**North Carolina Department of Health and Human Services**  
**Division of Public Health**

August 3, 2020

RE: Tropical Smoothie Cafe  
1546 NC Hwy 24/87  
Cameron, NC 28326

This letter acknowledges review of the plan for the above remodel of the referenced establishment. The original plan dated 03/05/2020 and specifications are approved with the following comments:

1 FLOOR FINISH PLAN
SCALE: 1/4" = 1'-0"

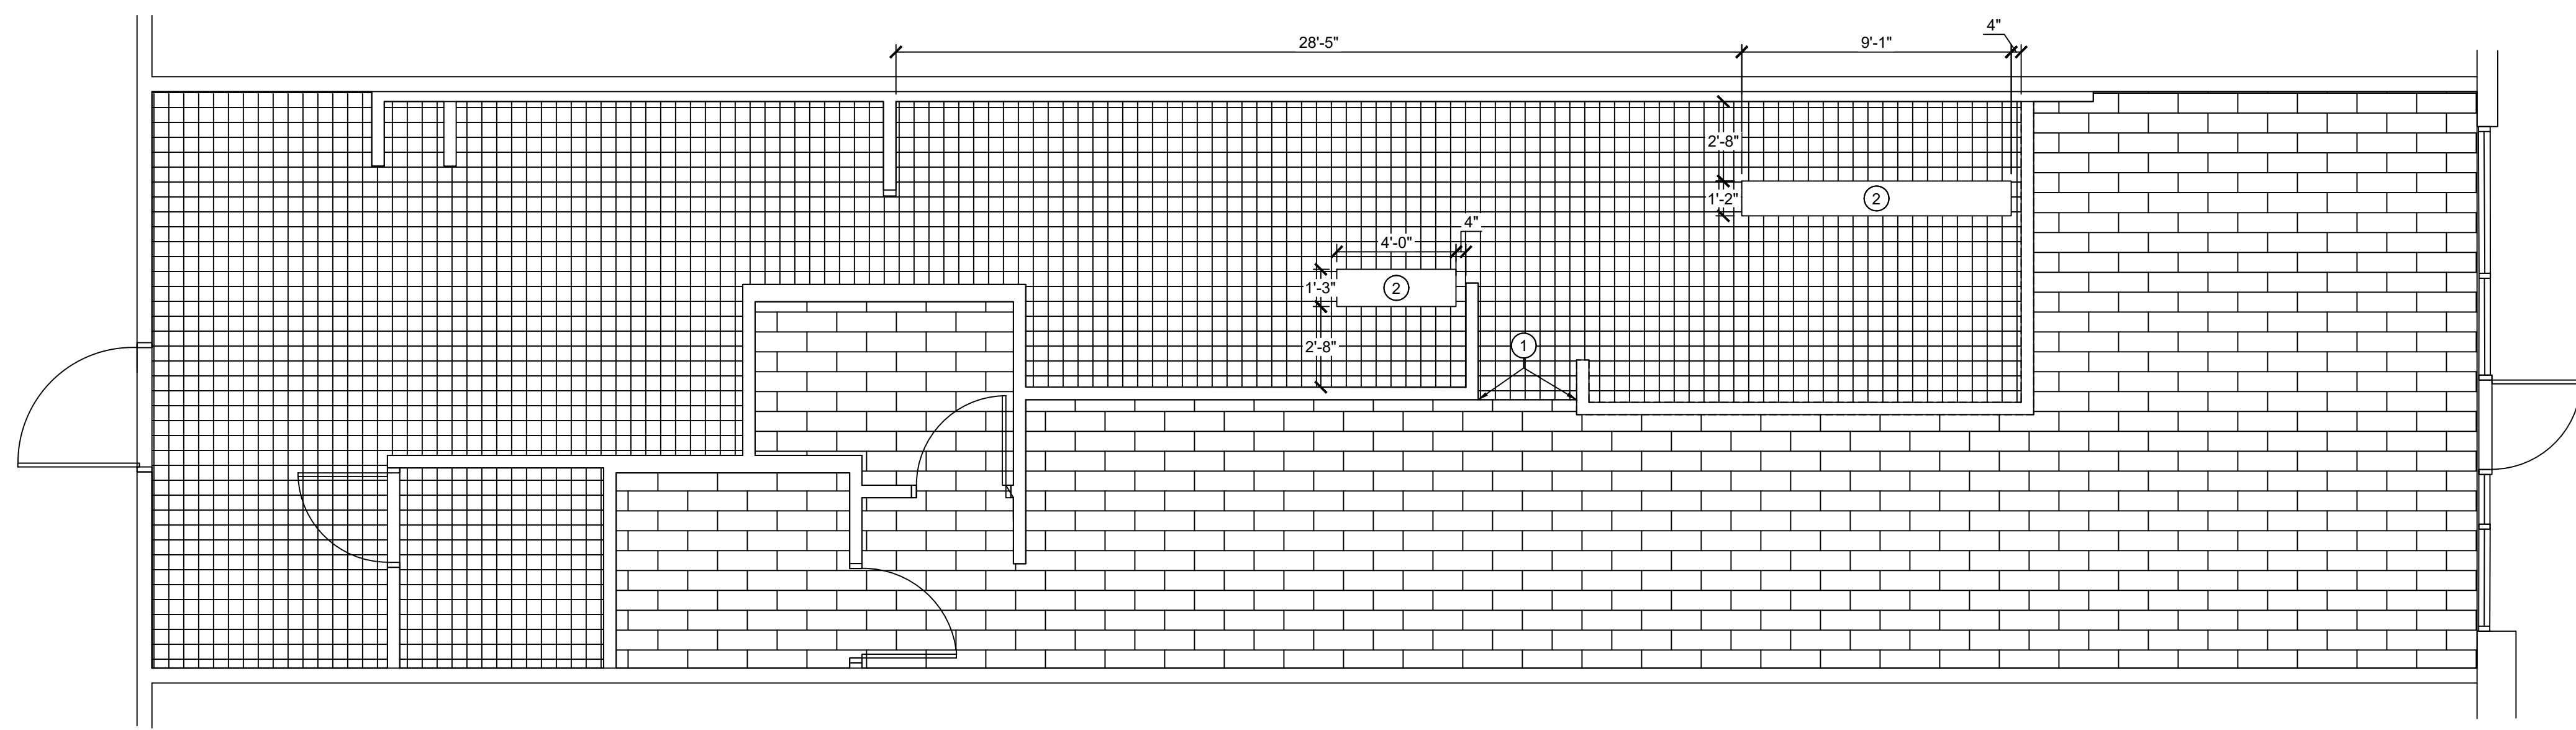
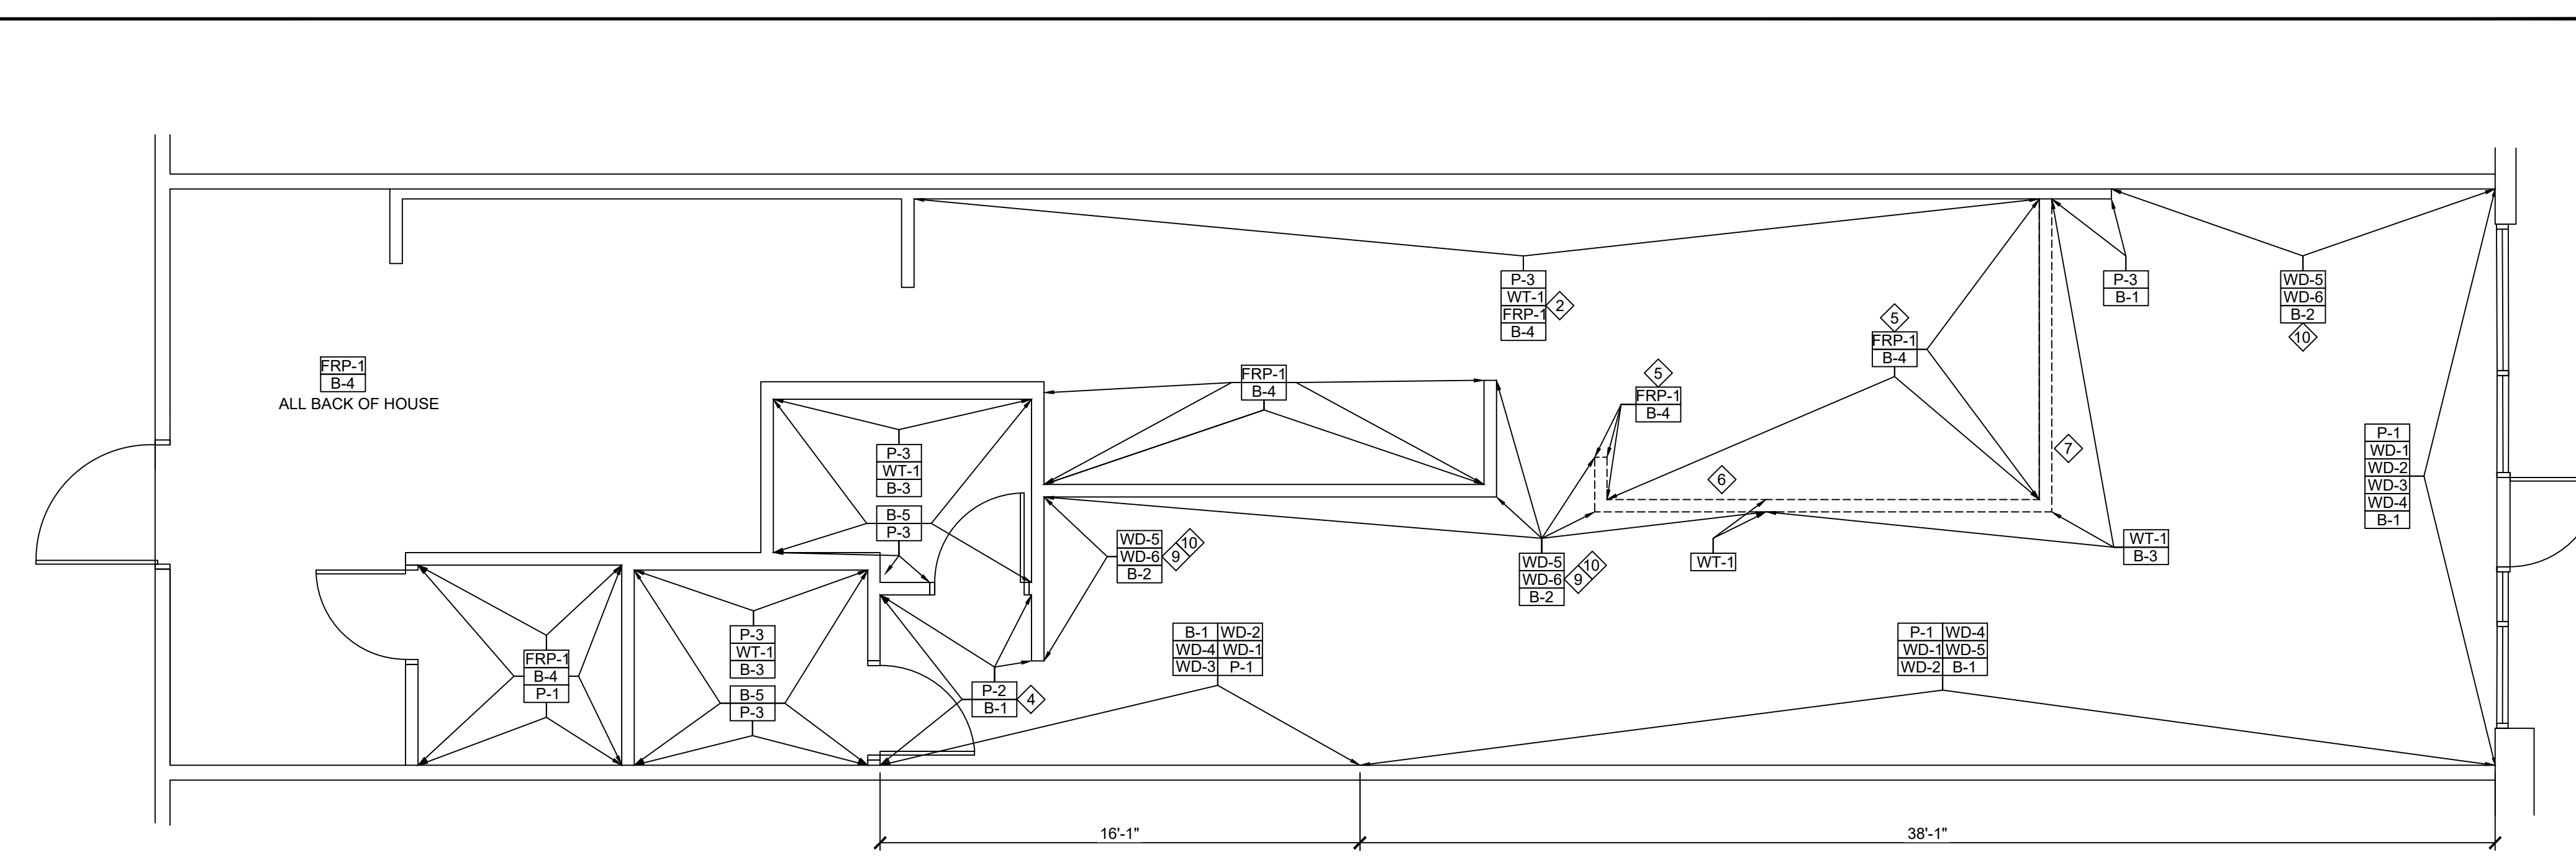
3. Floors, walls, and ceilings must comply with Subparts 6-101 and 6—201 of the NC Food Code. As a reminder, flooring in all food service areas, walk-in coolers and freezers and toilet rooms must be coved. The finishes shown on the application and on the Finish Plan A2.1 are approved when meeting these conditions.
